Access Report

Project Description: Erection of a mixed-use development comprising of commercial tenancies, residential apartments, basement parking and two pools. (S4.55 Submission)

Project Address: 242-244 Beecroft Road, Epping

Report Type: Access Report to accompany a S4.55
Development: 242-244 Beecroft Road, Epping

**Drawing Title**  
 GA Plans  
 Basement 03

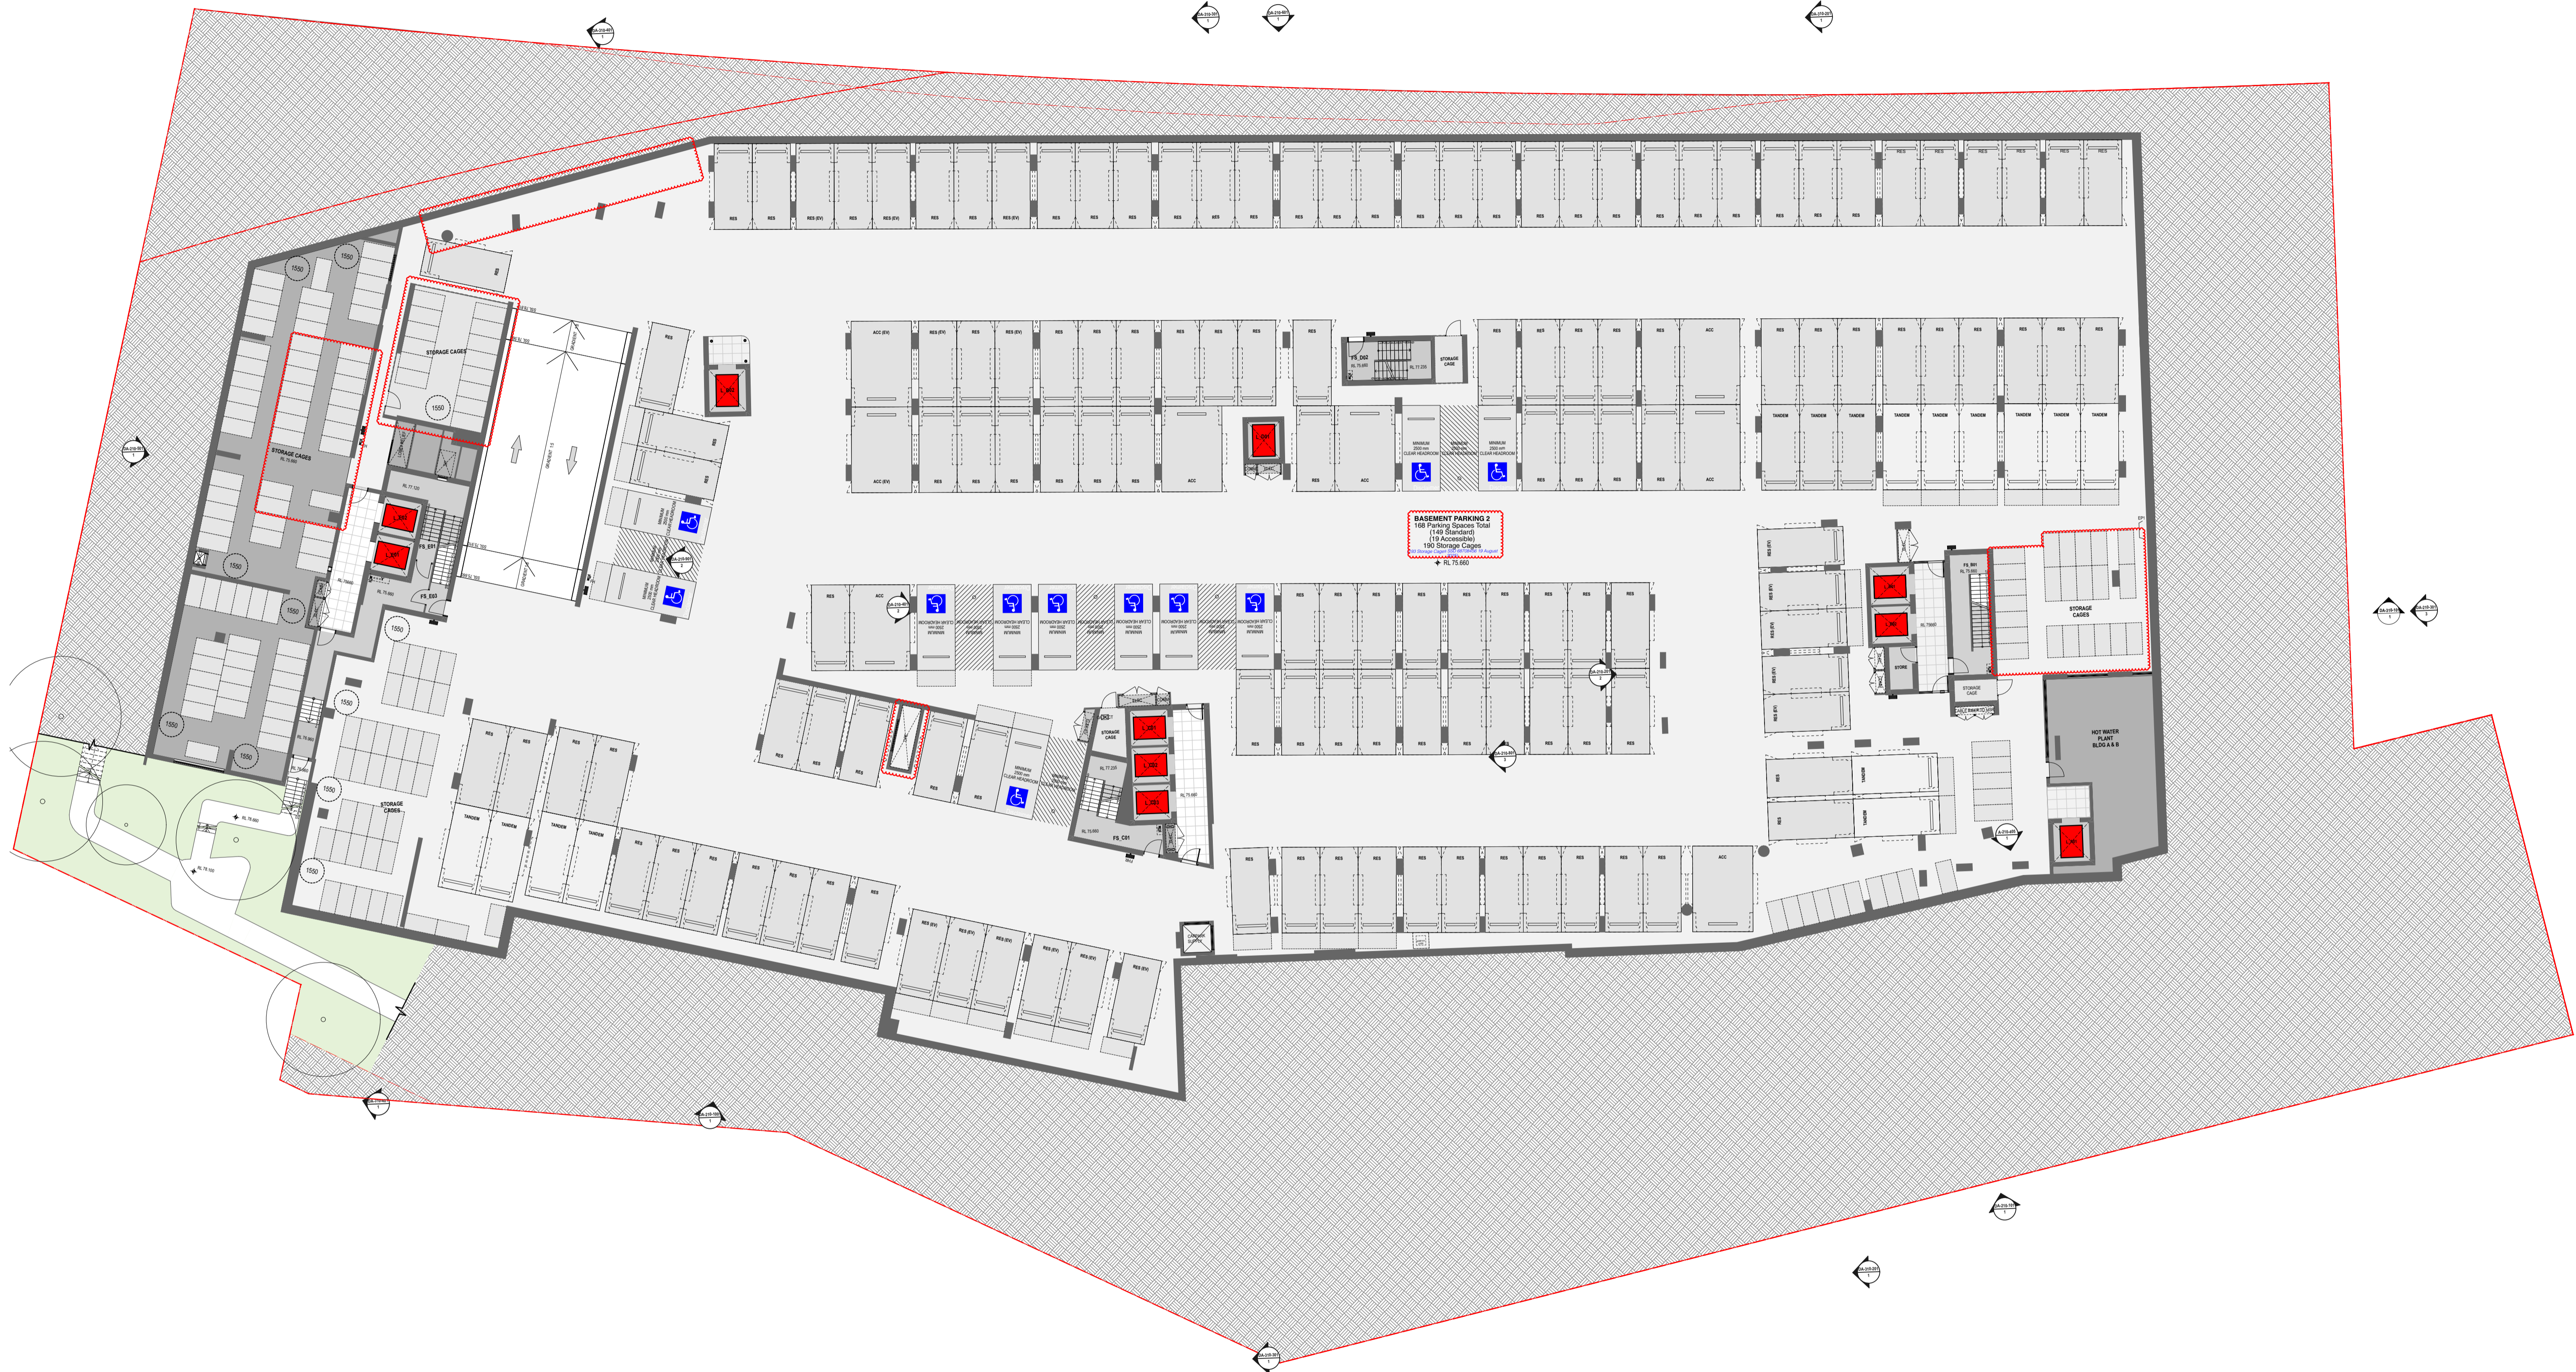
D4D1/D4D2	<p>Level 16 door exiting corridor near sanitary facilities is required to comply with AS 1428.1 To be assessed prior to CC</p> <p>Lobby doors in basement to comply with AS 1428.1, 110mm hinge side clearance is required where door opens towards occupant Redesign prior to CC</p> <p>Door at end of corridor leading to retail from BOH facilities requires 510mm latch side clearance Redesign prior to CC</p>
D4D4	<p>1540mm x 2070mm turning space is required within 2m of the end of each accessway, please see:</p> <ul style="list-style-type: none">- Basement 01 near EB103- Building B level 7 <p>Redesign prior to CC or performance solution</p>
D4D11	<p>Building B pool that is to be 70m in perimeter is required to be accessible To be assessed prior to CC</p>
Adaptable	<p>Circulation to adaptable kitchens are required to comply pre-adaption. 1550mm circulation is required at CC stage. Performance solution at CC stage</p>

Compliance Status	
Capable of compliance	<p>Level 16 door exiting corridor near sanitary facilities is required to comply with AS 1428.1 To be assessed prior to CC</p> <p>Lobby doors in basement to comply with AS 1428.1, 110mm hinge side clearance is required where door opens towards occupant Redesign prior to CC</p> <p>Door at end of corridor leading to retail from BOH facilities requires 510mm latch side clearance Redesign prior to CC</p>

**Drawing Title**  
 GA Plans  
 Level 07

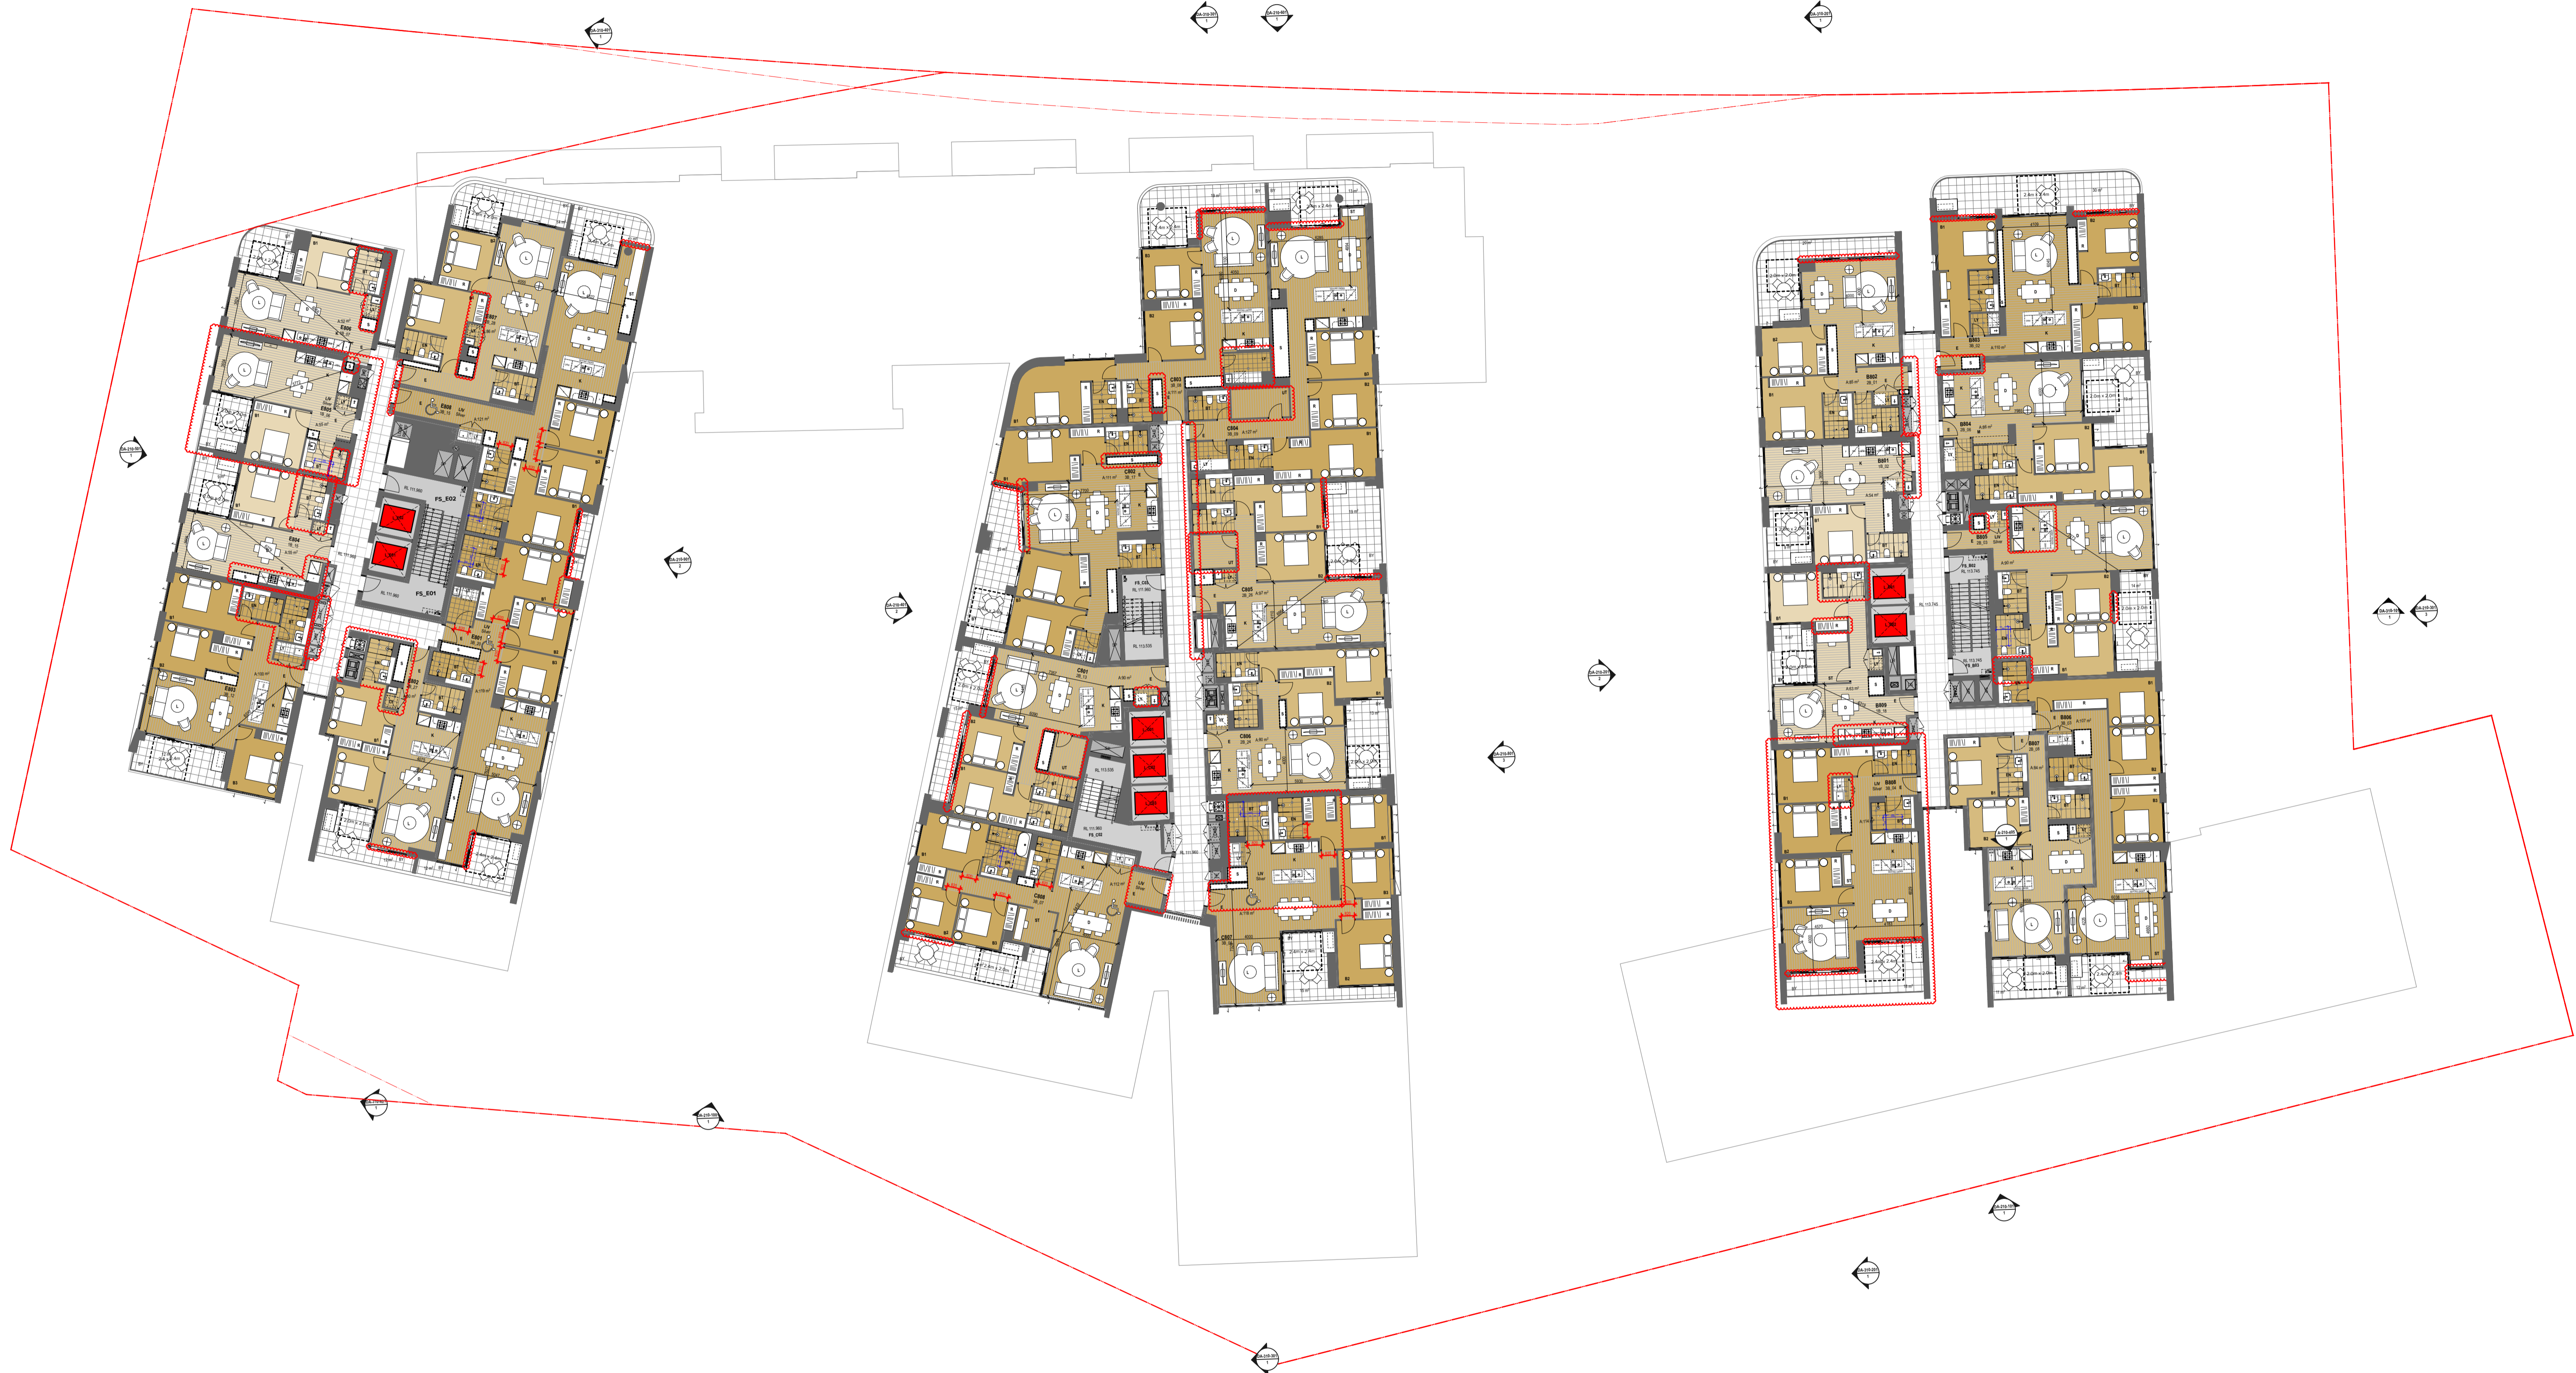
Compliance Status	
Capable of compliance	<p>1540mm x 2070mm turning space is required within 2m of the end of each accessway, please see:</p> <ul style="list-style-type: none"> - Basement 01 near EB103 - Building B level 7 <p>To be assessed prior to CC</p> <p>All stairs and handrails require tactiles to the top and bottom and double handrails</p> <p>To be assessed prior to CC</p>
